MERIDIAN ROAD & BENT GRASS MEADOWS DRIVE

GRADING AND EROSION CONTROL PLANS

MERIDIAN ROAD & BENT GRASS MEADOWS DRIVE
GRADING & EROSION CONTROL PLANS
FOR
CHALLENGER COMMUNITIES, LLC

COVER SHEET

C1.0

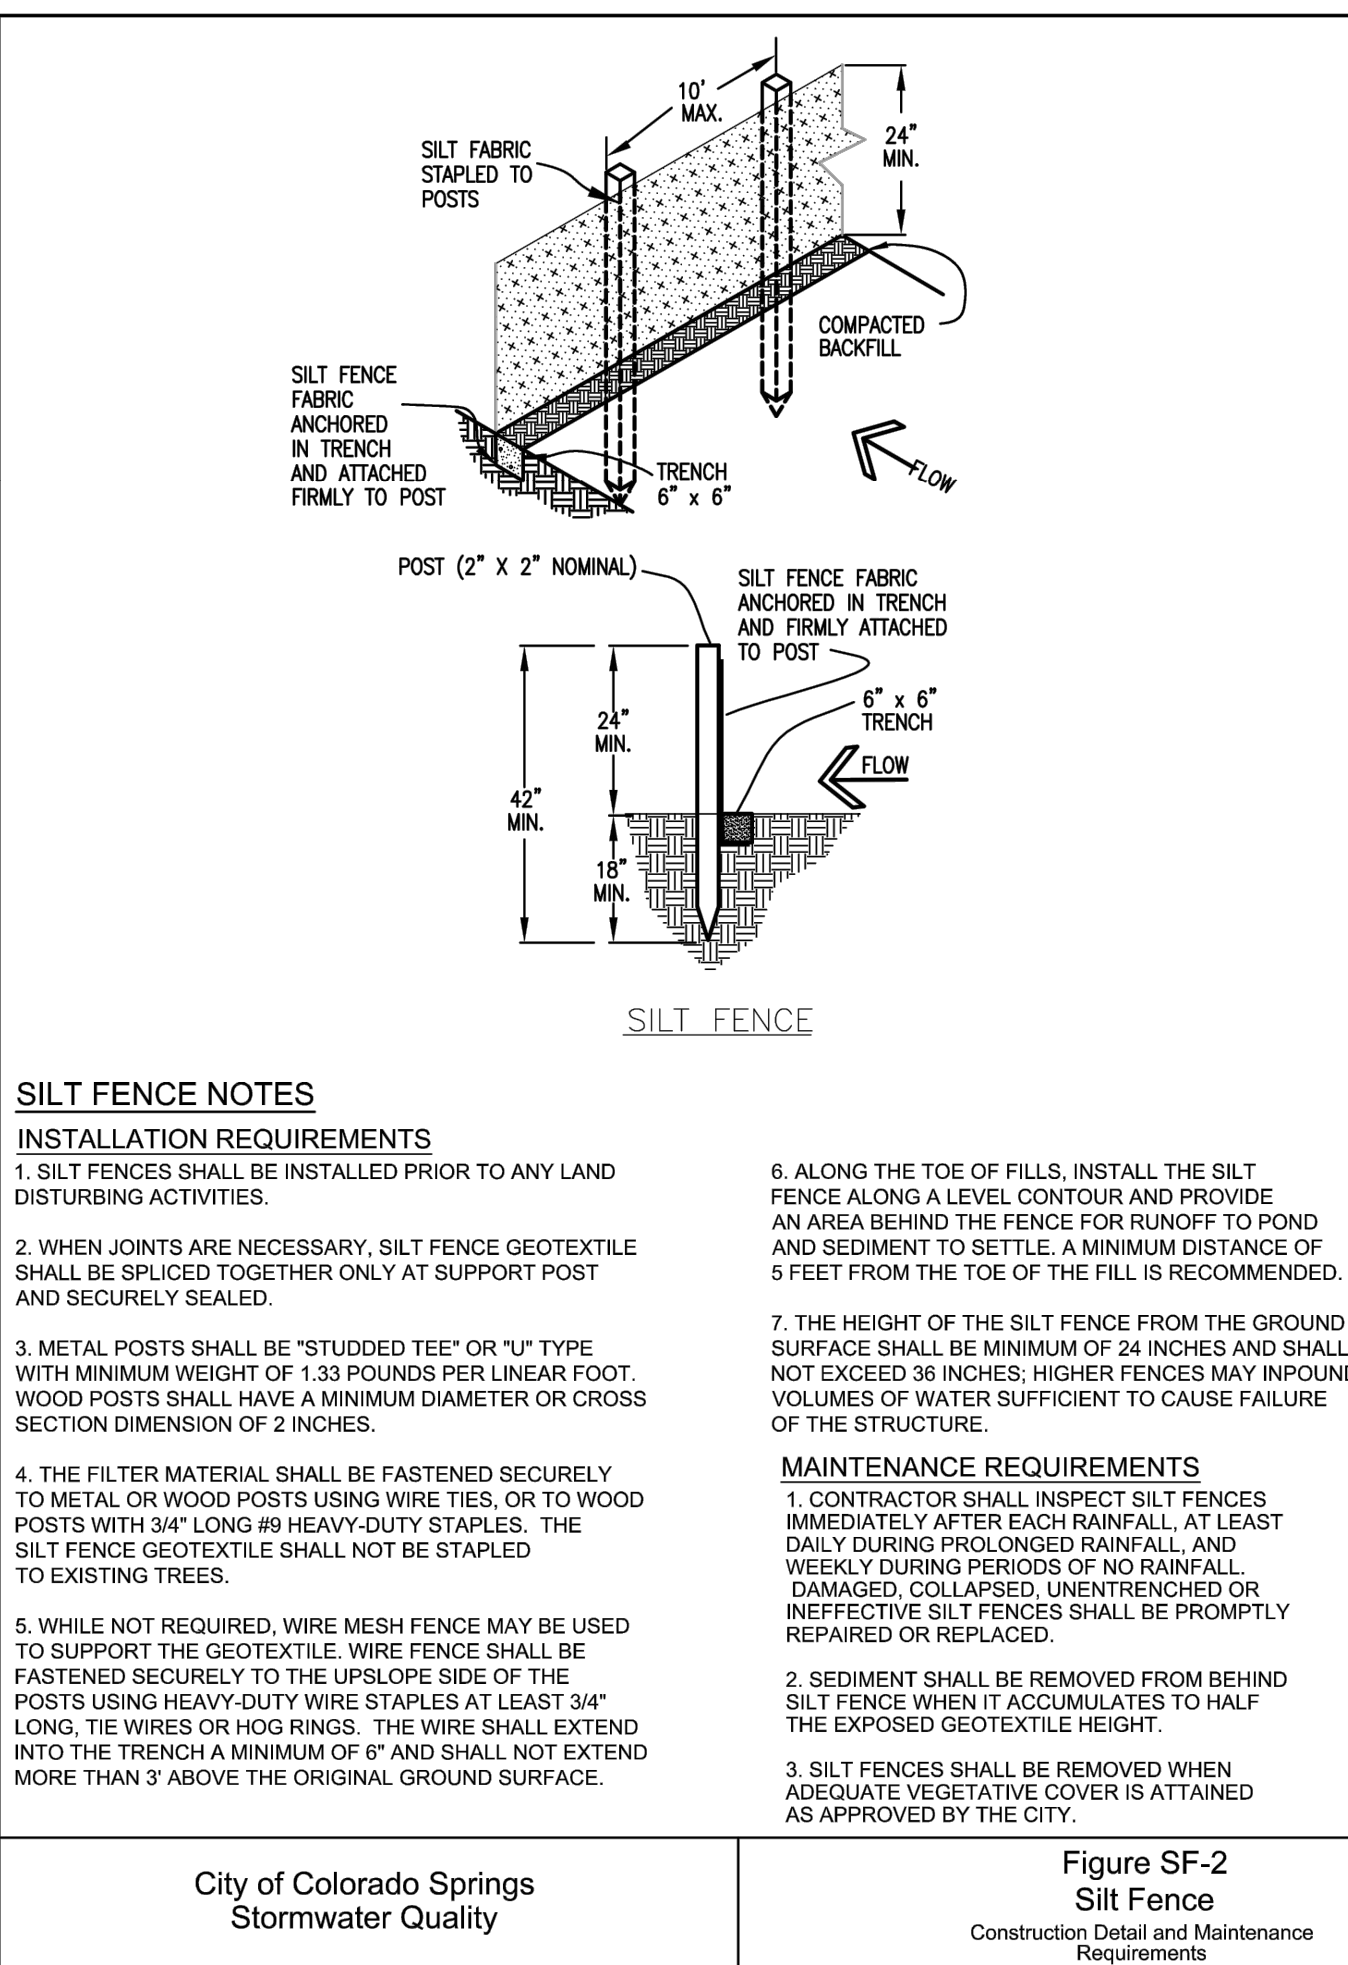
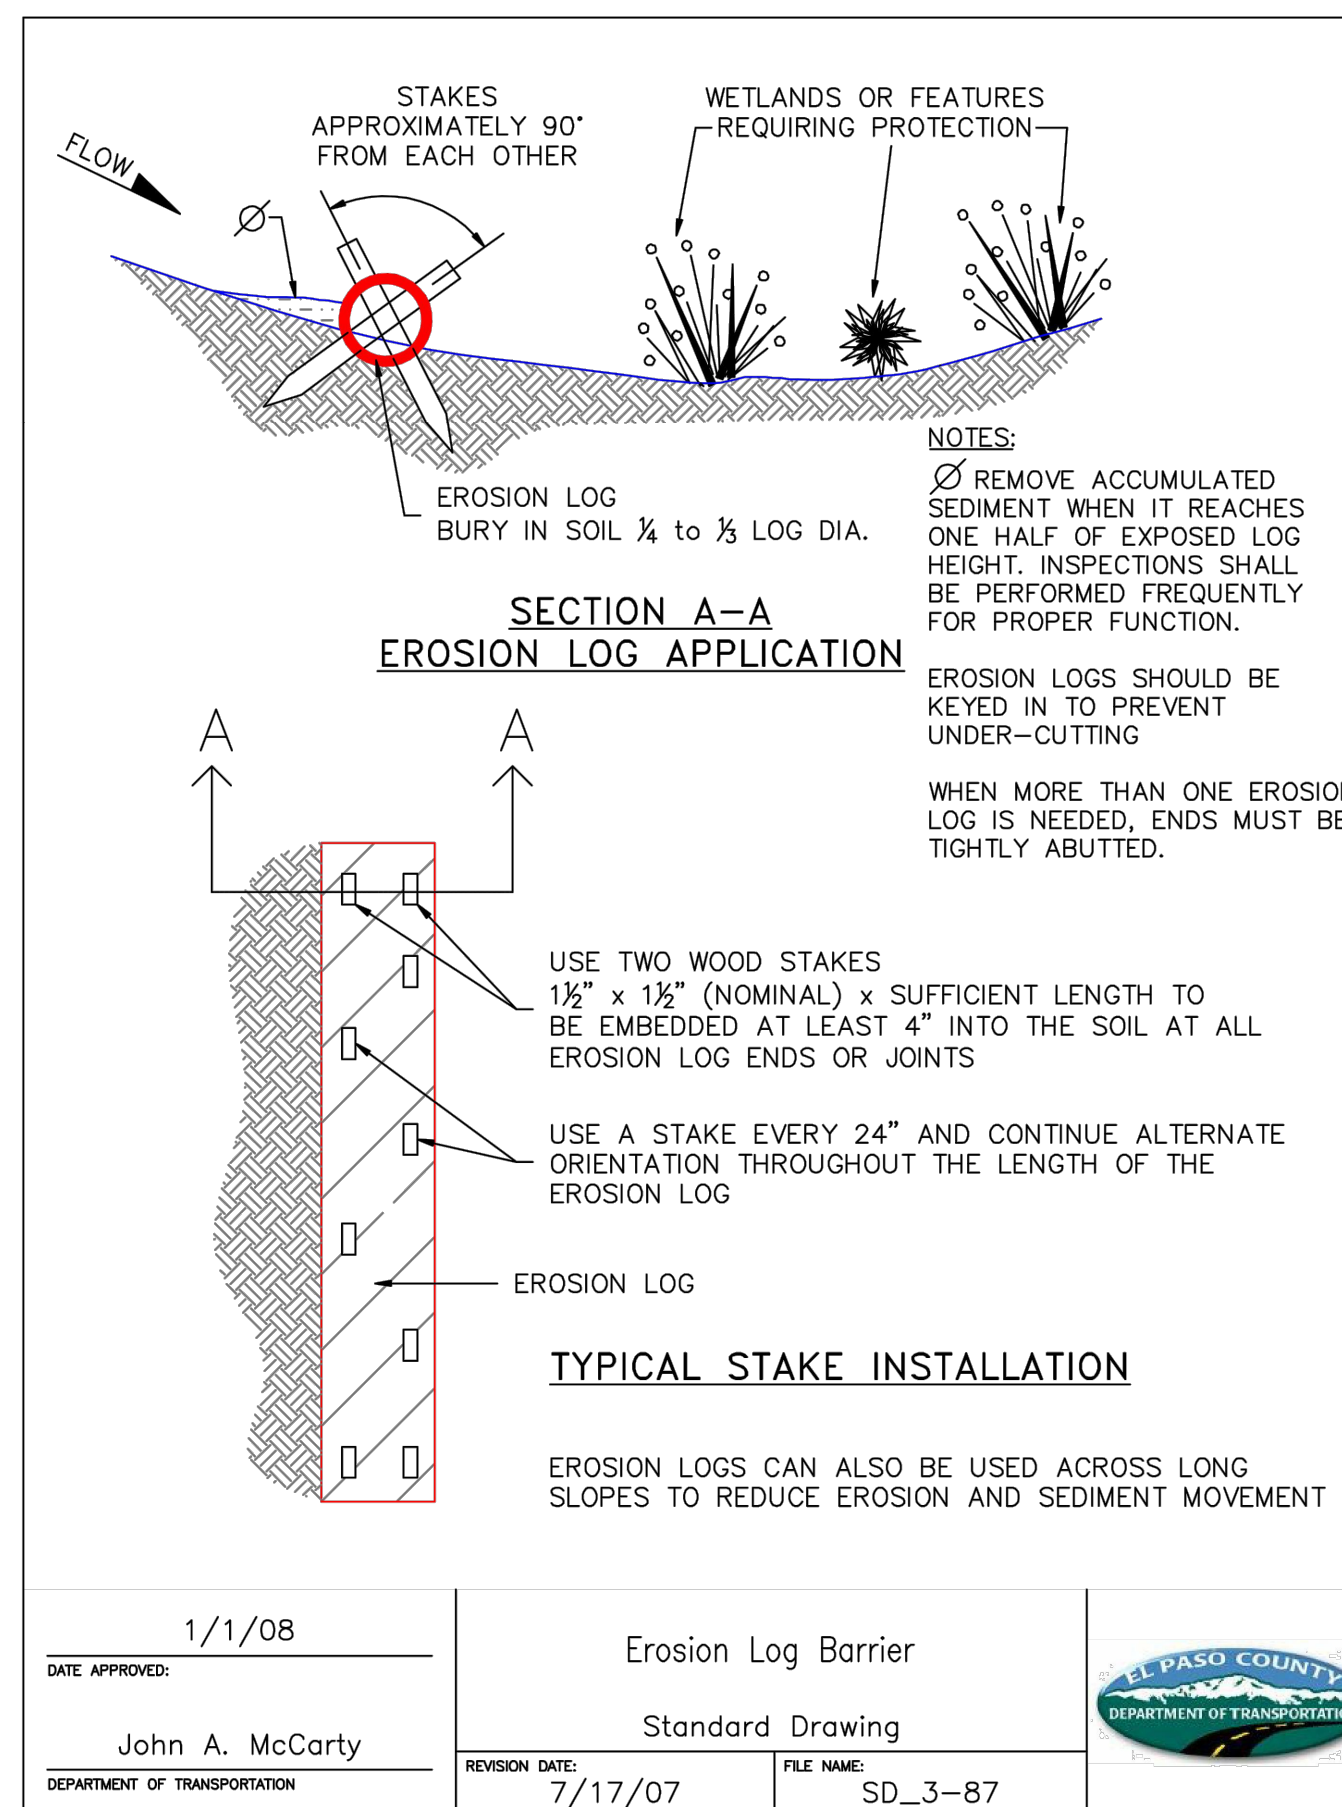
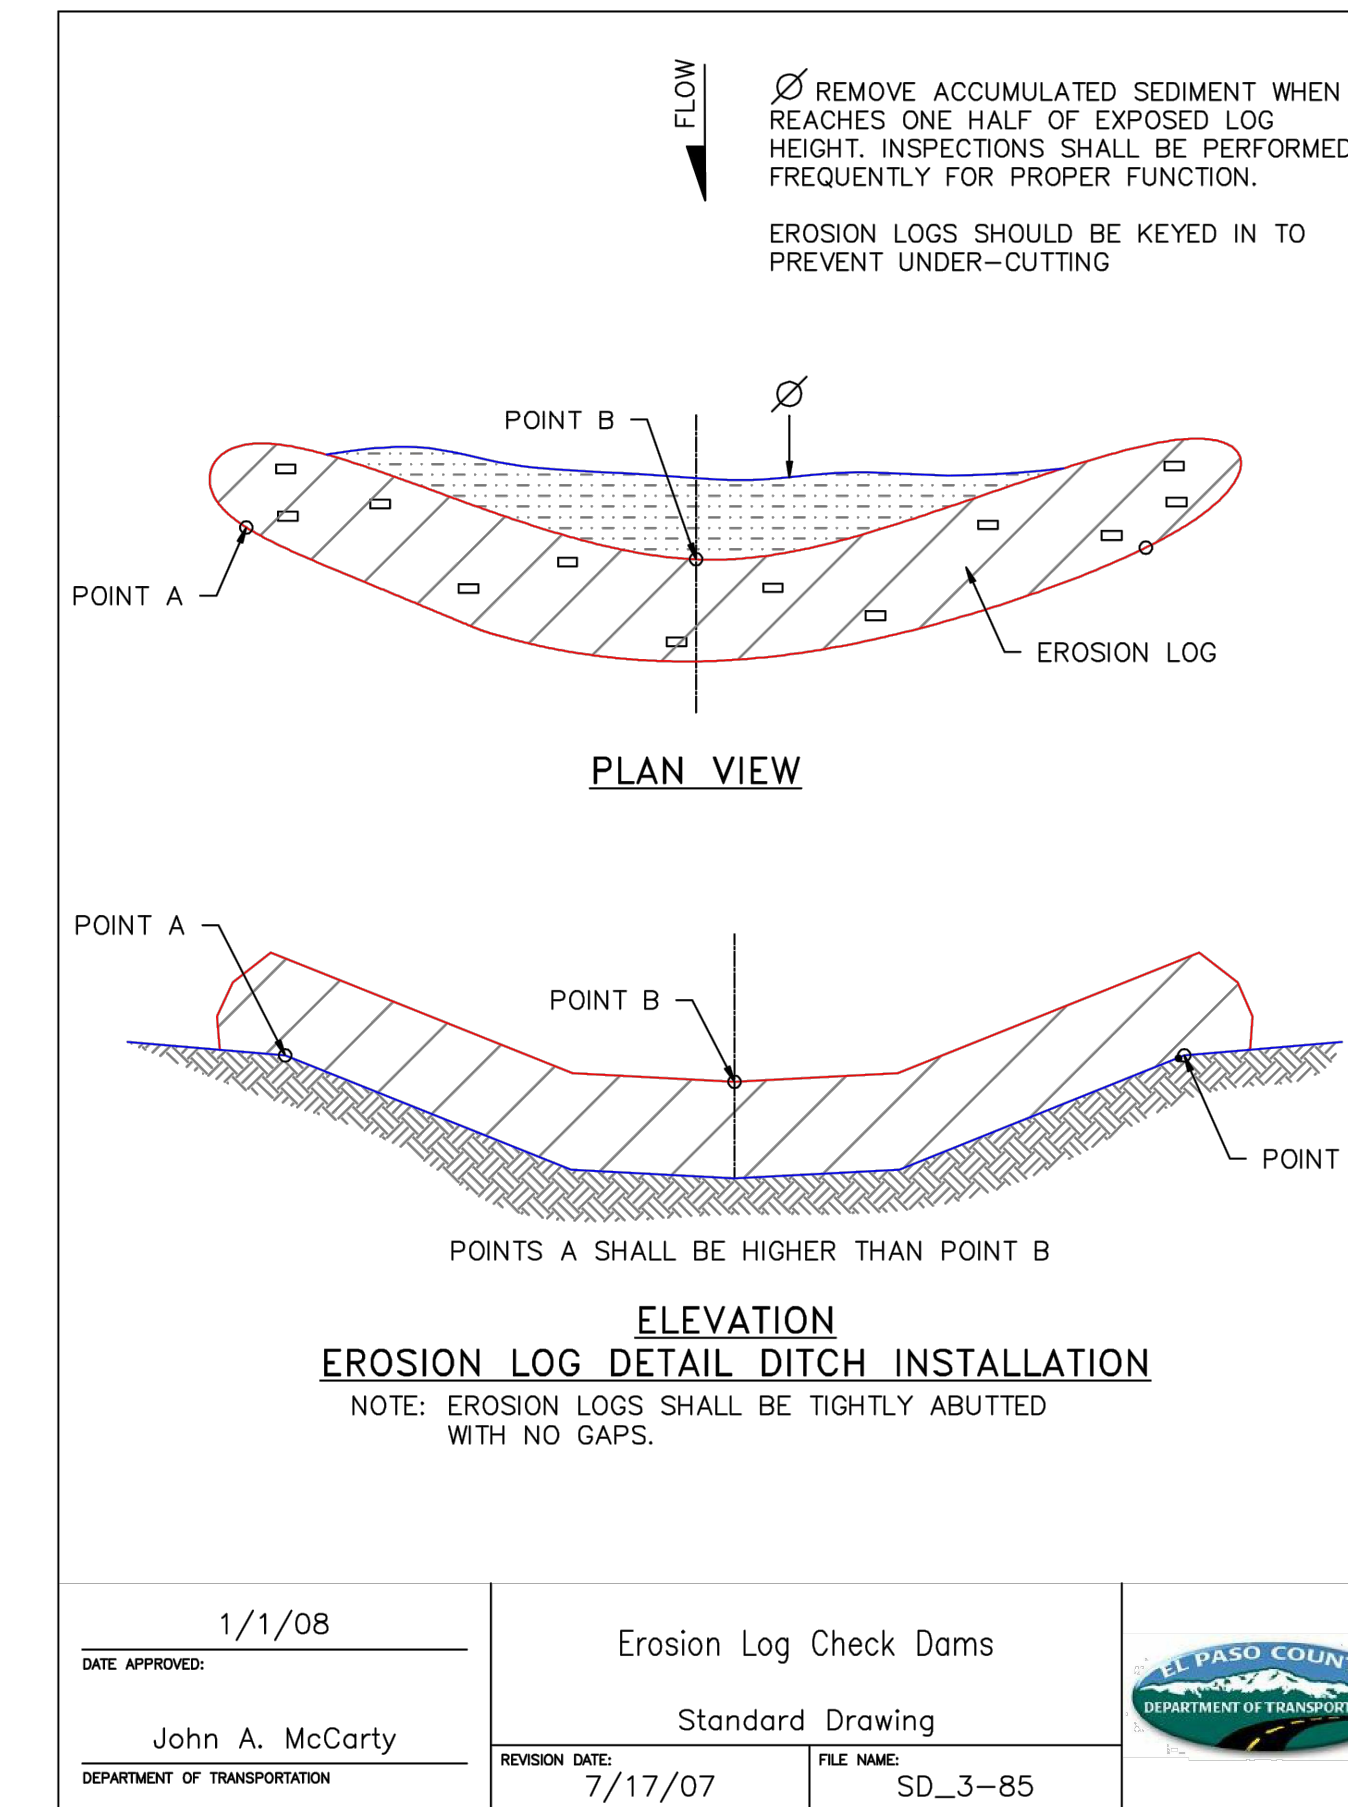
update notes in accordance with GEC Checklist Section 3.
Unresolved.

- CONCRETE WASH WATER SHALL BE CONTAINED AND DISPOSED OF IN ACCORDANCE WITH THE 409 WAS SURFACE OR SUBSURFACE STORM DRAINAGE SYSTEM OR FACILITIES. CONCRETE WASHOUT SHALL NOT BE DISCHARGED TO STATE WATERS, INCLUDING ANY STORMWATER MAY BE PRESENT, OR WITHIN 50 FEET OF A SURFACE WATER BODY. ADD: "creek or stream."

- IF STORMWATER FLOW IN THE FLOW LINE OF THE CURB AND GUTTER OR IN THE DITCH FLOW LINE ADD: "except with approved sediment control measures."
- OWNER/DEVELOPER AND THEIR AGENTS SHALL COMPLY WITH THE "COLORADO WATER QUALITY CONTROL ACT" (TITLE 25, ARTICLE 8, CRS), AND THE "CLEAN WATER ACT" (FEDERAL LAW, 33 USC 1251). THE REQUIREMENTS OF THE LAND DEVELOPMENT CODE, DCM VOLUME II AND THE EOM APPENDIX I. ALL APPROPRIATE PERMITS MUST BE OBTAINED BY THE CONTRACTOR. (NPDES, FLOODPLAIN, 404, FUGITIVE DUST, ETC.). IN THE EVENT OF CONFLICTS BETWEEN THESE REQUIREMENTS AND OTHER LAWS, RULES, OR REGULATIONS OF OTHER AGENCIES, THE MOST RESTRICTIVE LAWS, RULES, OR REGULATIONS SHALL APPLY.

NOTES REVISED IN ACCORDANCE WITH GEC CHECKLIST.
